The Sizewell C Project

9.120 Comments on Earlier Deadlines, Subsequent Written Submissions to ISH11-14 and Comments on Responses to Change Request 19

SIZEWELL C PROJECT –
COMMENTS ON EARLIER DEADLINES, SUBSEQUENT
WRITTEN SUBMISSIONS TO ISH10-14 AND
COMMENTS ON RESPONSES TO CHANGE REQUEST 19

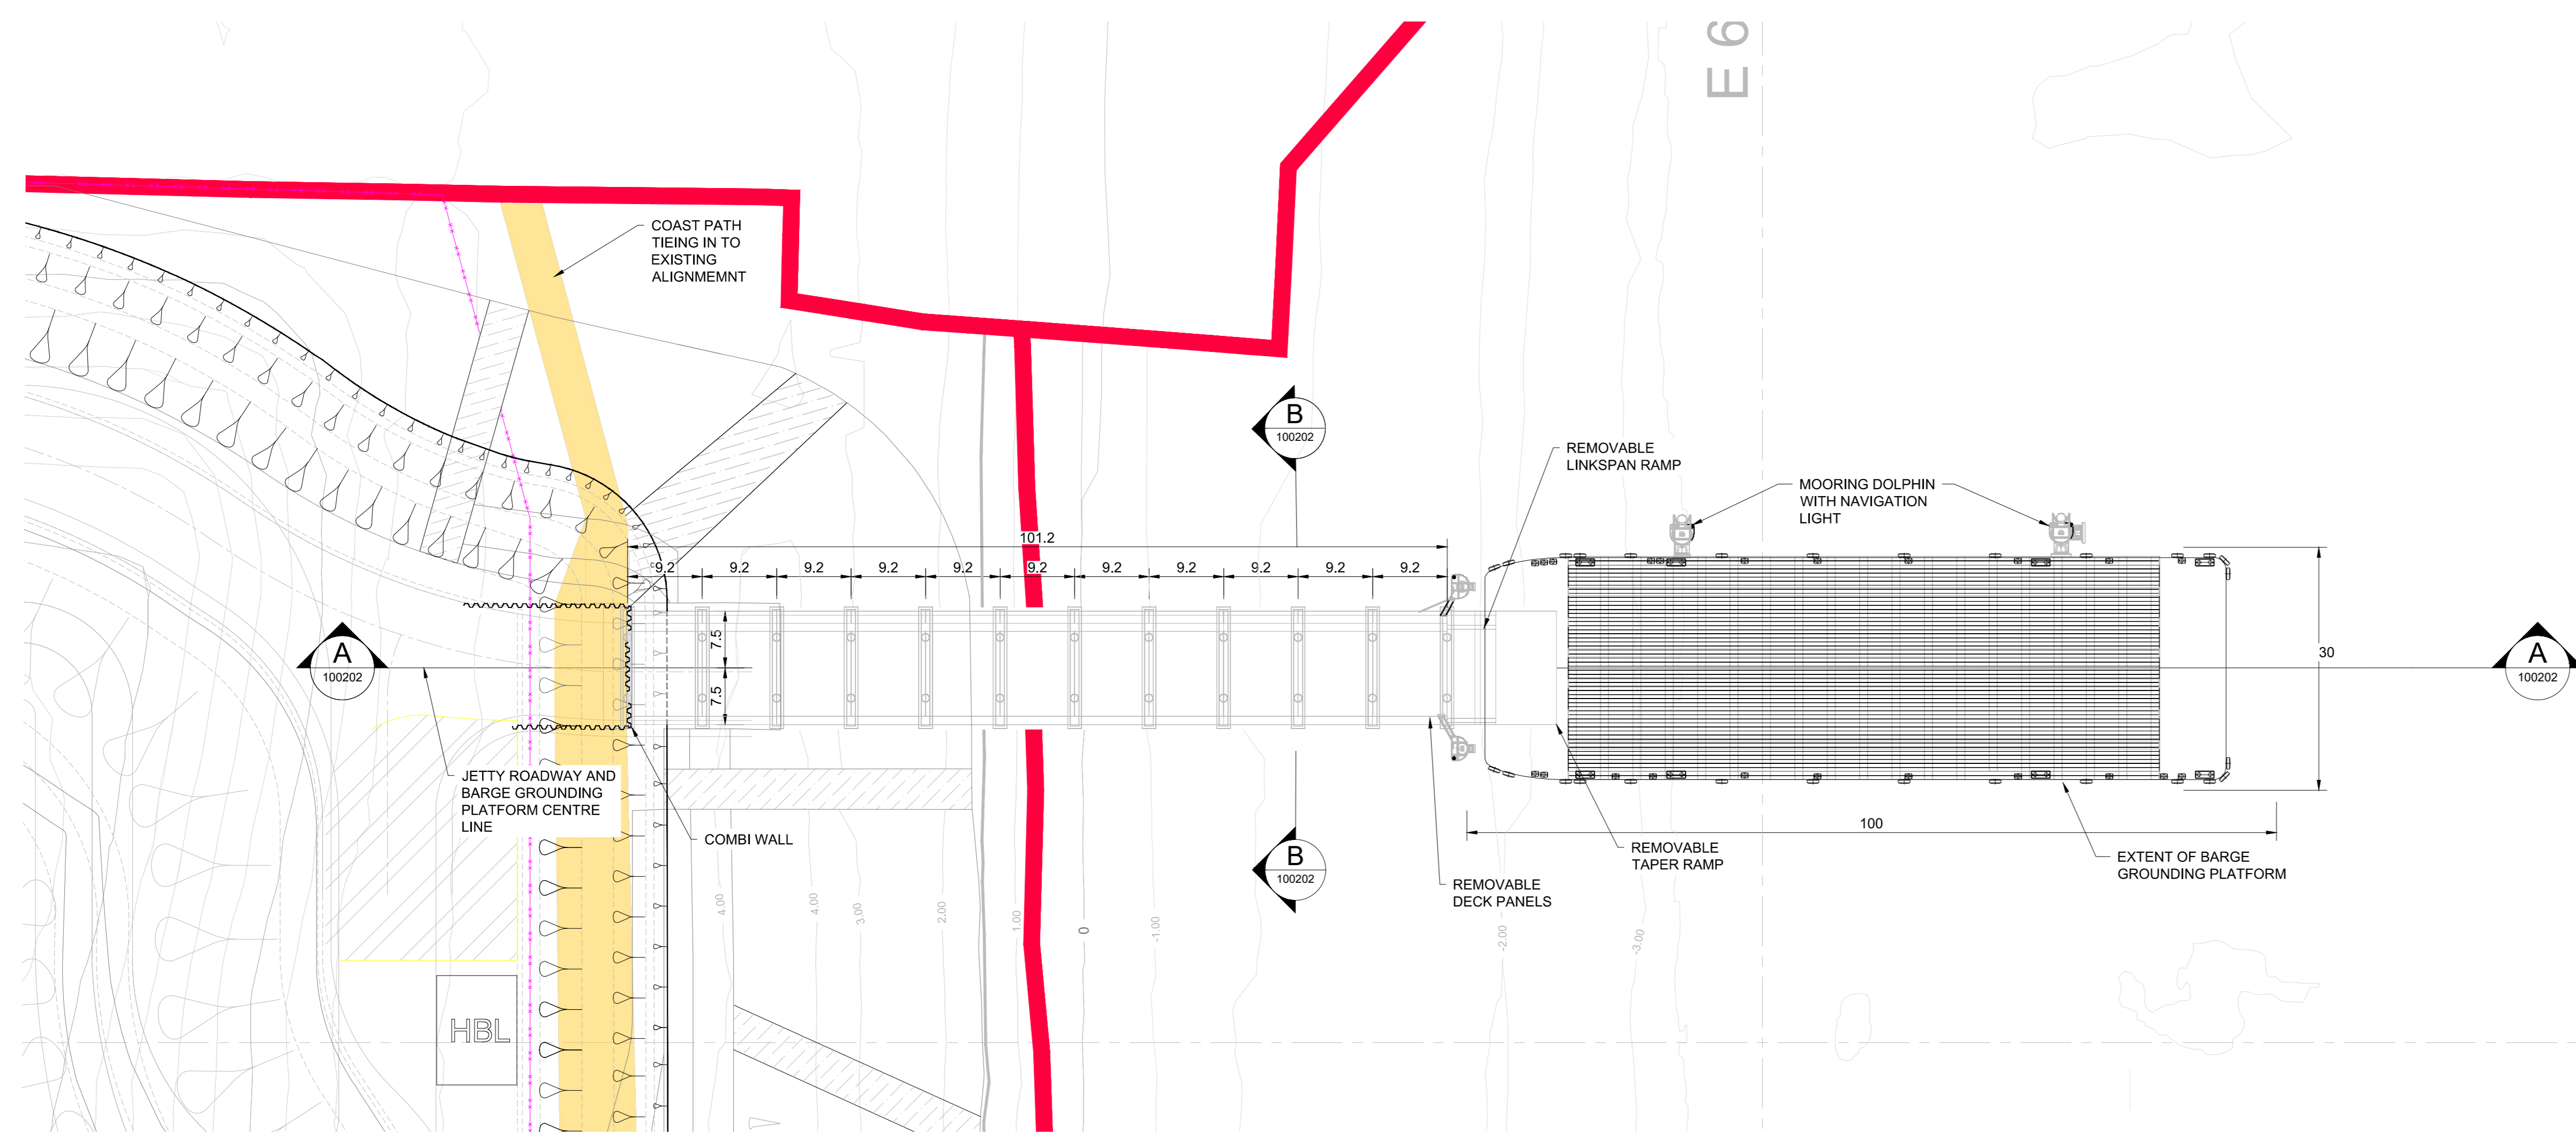
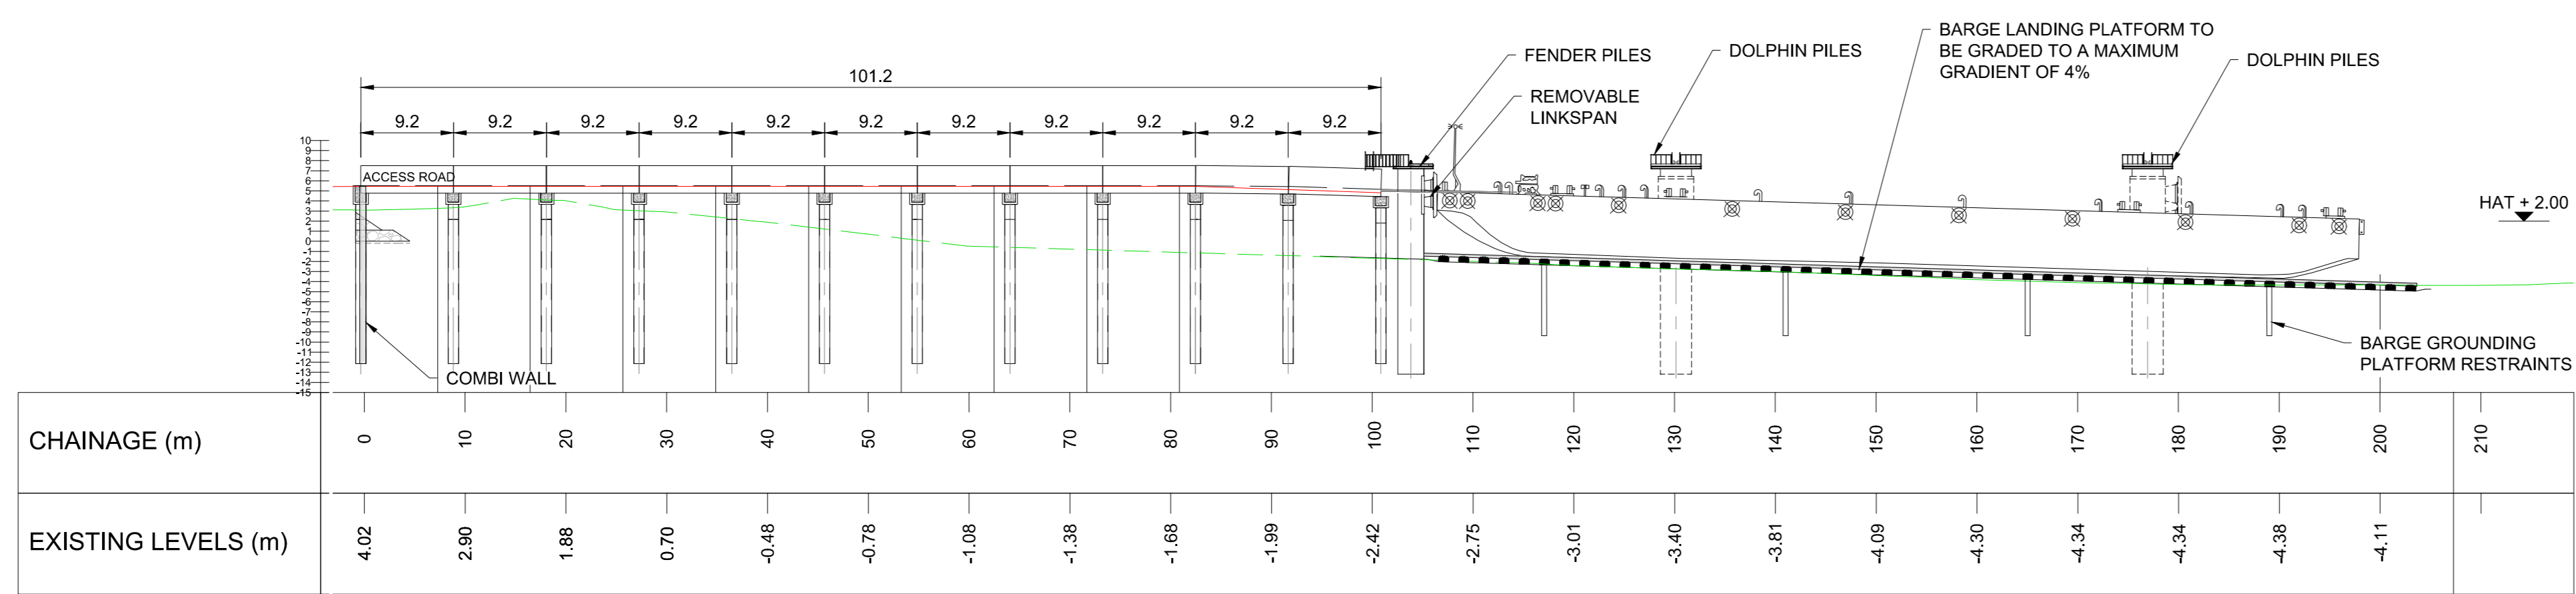
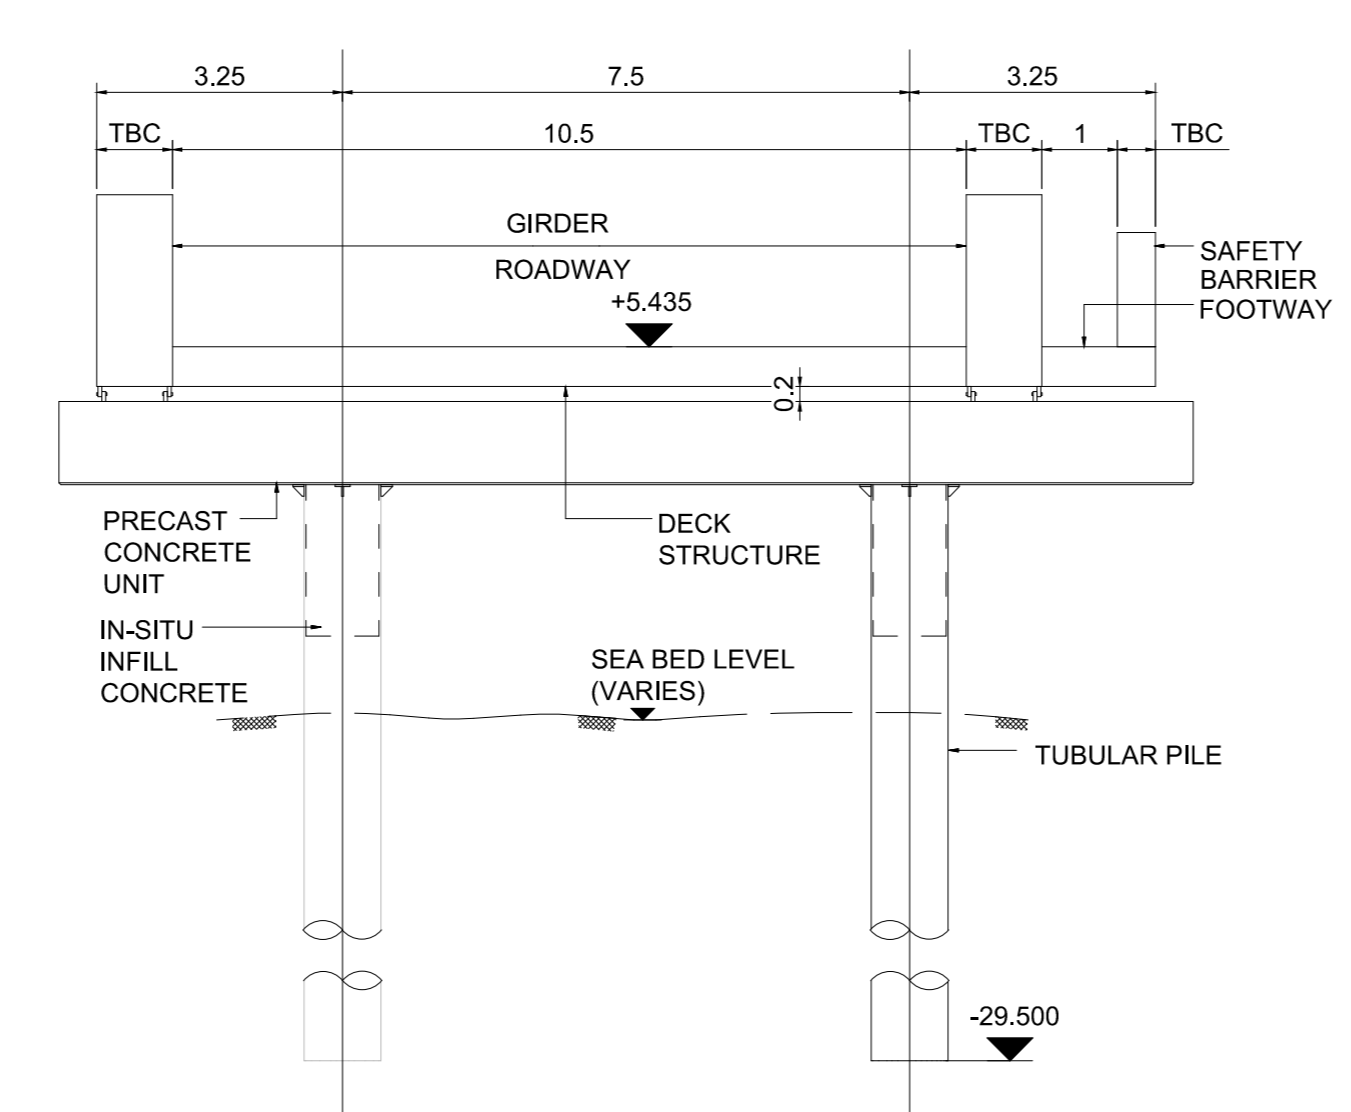
2.3.12 With regards to Main Development Site, Permanent BLF (SZC Construction plan (Ref SZC-SZ0100-XX-000-DRW-100202), ESC requested clarification on a number of points.

- **Green line – Assumed indicative beach profile** – SZC Co. can confirm that the green line showing the beach profile is accurate for the chainage. The green line has been taken from the 2017 ground/bathymetric model.

- **Barge grounding platform and restraints** – the **Construction Method Statement** (Doc Ref. 10.3) confirms that the grounding platform will be made of concrete, or similar. Further details are included at Paragraph 3.1.70 of the CMS.

- **Tracks/pathways across hard and soft coastal defence** – The coast path and the subsidiary paths installed to provide temporary diversion of the coast path around the permanent BLF during construction are not hard structures which would compromise erodibility of the soft coastal defence feature. This is secured in Paragraph 3.1.122 of the **Construction Method Statement**. The maintenance tracks will be hard structures and are proposed to permit access to the beach either side of the BLF. They will be set below the SCDF recharge level to maintain access and will be designed not to adversely impact littoral drift. This is secured in Paragraph 3.1.123 of the **Construction Method Statement**. With regards to how the permanent BLF will affect or be affected by construction of an adaptive HCDF, the adaptive HCDF will only be required if future climate change effects exceed currently assumed criteria. Should it become necessary to construct the adaptive design and should the permanent BLF remain necessary at the time, then the adaptive HCDF would be designed to accommodate the permanent BLF without redevelopment.
